From: [REDACTED]
Sent: 27 April 2018 14:54
To: Planning.Responses
Cc: Dawn Hall
Subject: **Warning Active Content** Planning Services Response P/25/18/PL

TO:	Arun District Council FAO: Andrew Wood
FROM:	Highways, WSCC
DATE:	27/04/2018
LOCATION:	Jenin, Nyetimber Lane, Pagham, PO21 3JT
SUBJECT:	P/25/18/PL Demolition of existing garage, roof alterations to existing dwelling to provide first floor & 1 No. new dwelling in garden of existing dwelling.
DATE OF SITE VISIT:	
RECOMMENDATION:	☒ Advice ☐ Objection ☐ Modification ☐ No Objection ☐ More Information ☐ Refusal
S106 CONTRIBUTION TOTAL:	£N/A See below for breakdown.

Proposed Ground Floor Plan

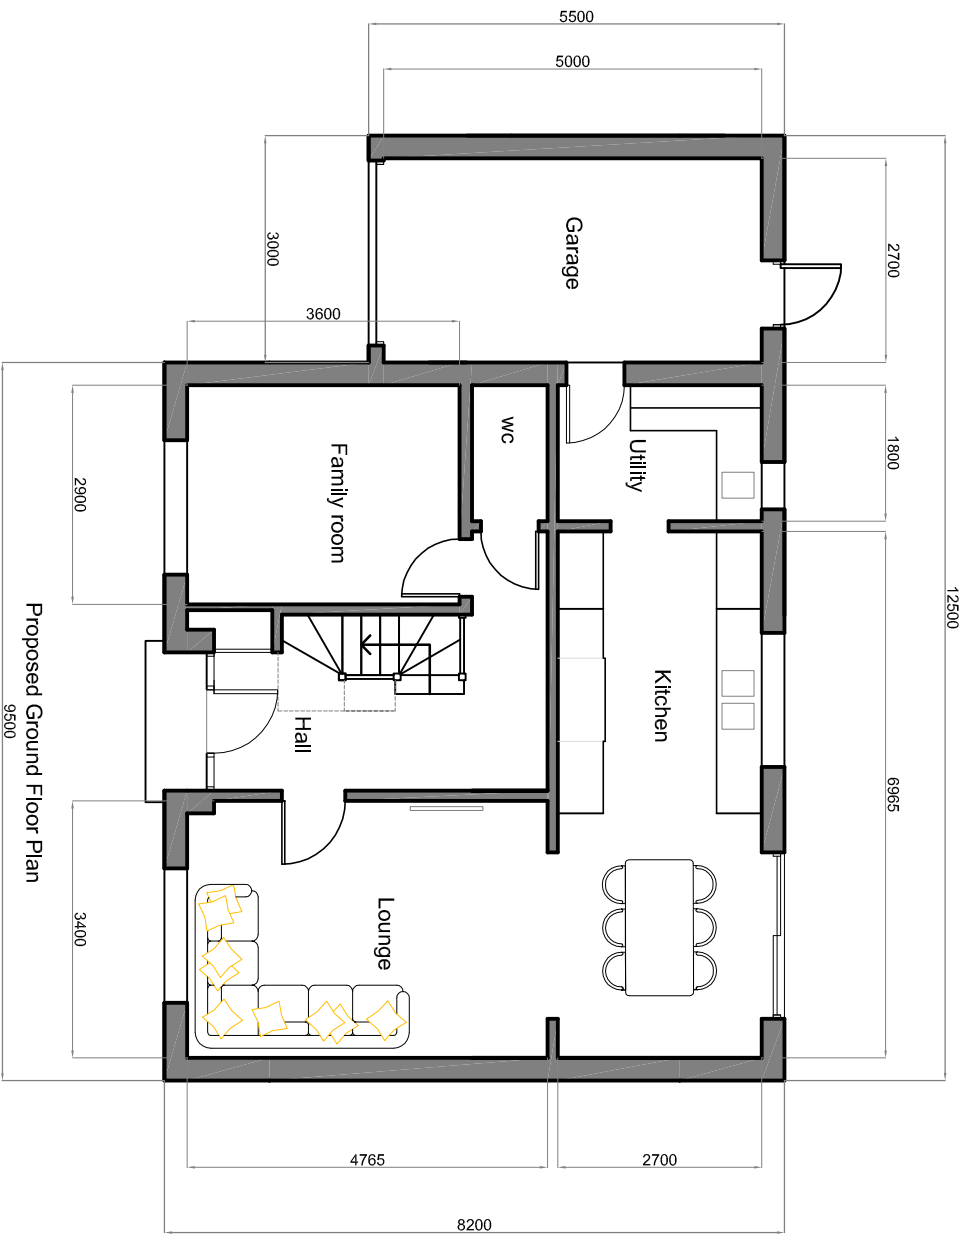
By taking measurements from the plans, the proposed incorporated garage for Jenin measures approximately 2.4m x 5m. This does not comply with Manual for Streets (MfS) minimum dimensions of 3m x 6m for a single garage and therefore cannot be counted towards parking provision. The measurements for the new dwelling show garage dimensions of 2.7m x 5m which also does not meet MfS standards and so cannot be counted towards parking provision. The WSCC car parking calculator would envision a total of 4 parking spaces for dwellings of this size in this location. The LHA anticipate that the frontage for both the existing and proposed dwellings could accommodate one parking space per dwelling, but would still not meet the predicted parking requirement. Whilst on-street car parking is limited in the immediate vicinity there are comprehensive parking restrictions in the form double yellow lines prohibiting vehicles from parking in places that would be detriment to highway safety. We would not consider that highway safety would be detrimentally affected through the proposed car parking provision. The Local Planning Authority (LPA) may wish to consider the potential impacts of this development on on-street car parking from an amenity point of view.

Job Title		Jenin, Nye/timber Lane Bognor Regis PO21 3JT			
Drawing Title	Block Plan Proposed				
Client	R B				
Date	12/05/2017				
Drawn	P.J.G				
Scale	1:500 on A3				
Dwg No.	NT/L/BP/02				B

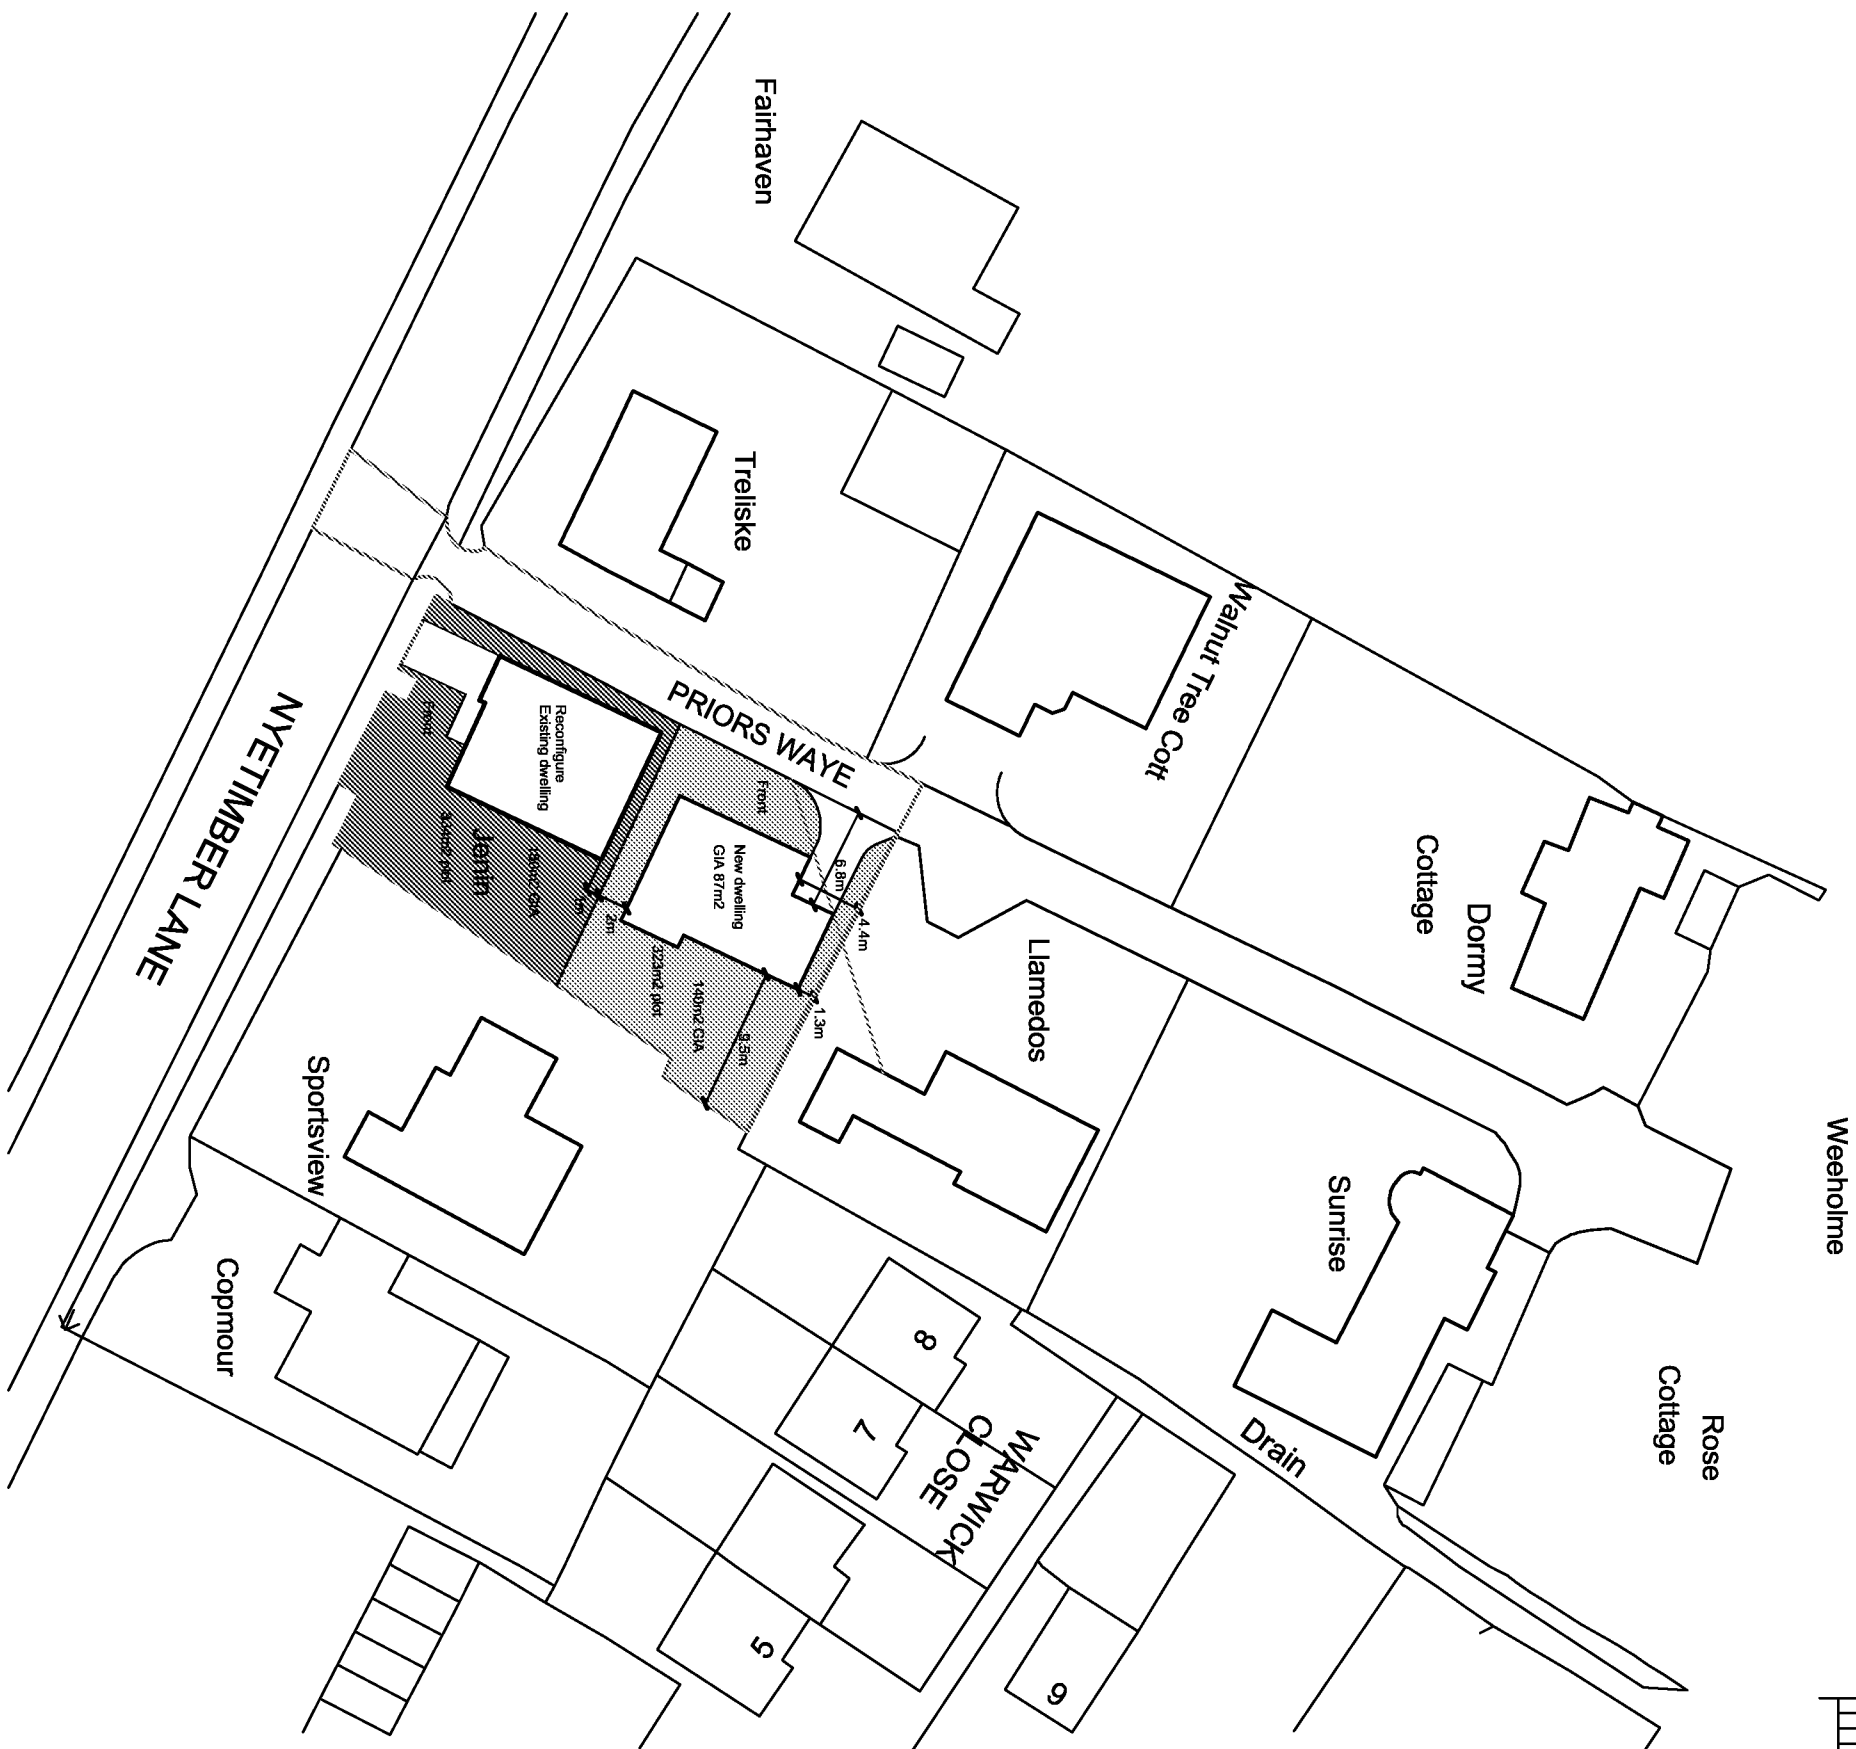
The site plan appears to show the relocation of the existing access to Jenin. The LHA ask for a more detailed plan of the new vehicle cross over (VCO) to be provided, including the total length of proposed dropped kerb. The applicant will need to apply for a VCO license from the local area office to both close the existing access and create the new access, if this application is approved. Please be aware all street furniture, including telephone poles, must be relocated at least 1.5m from the edge of the proposed new access to avoid obstructing the visibility splay. It will be the applicant's responsibility to arrange the relocation with the relevant utility company and cover the cost of the works.

The site plan also shows a new access onto Priors Waye which is a privately owned road. Permission must be sought from the proprietor of Priors Waye before any new accesses or other works that may affect the private road are commenced. The existing private driveway is not wide enough to support two vehicles passing one another. However, this is an existing situation which affects a small number of vehicles and vehicle journeys.

Matters relating to access during the construction of the proposed would need to be agreed prior to any works commencing. Vehicular access to the site is currently only possible from Nyetimber Lane. However, with the proposed new accesses to both Nyetimber Lane and Priors Waye, the applicant should set out which access they plan to use and how they plan for larger vehicles to access and make deliveries to the site during the construction period.
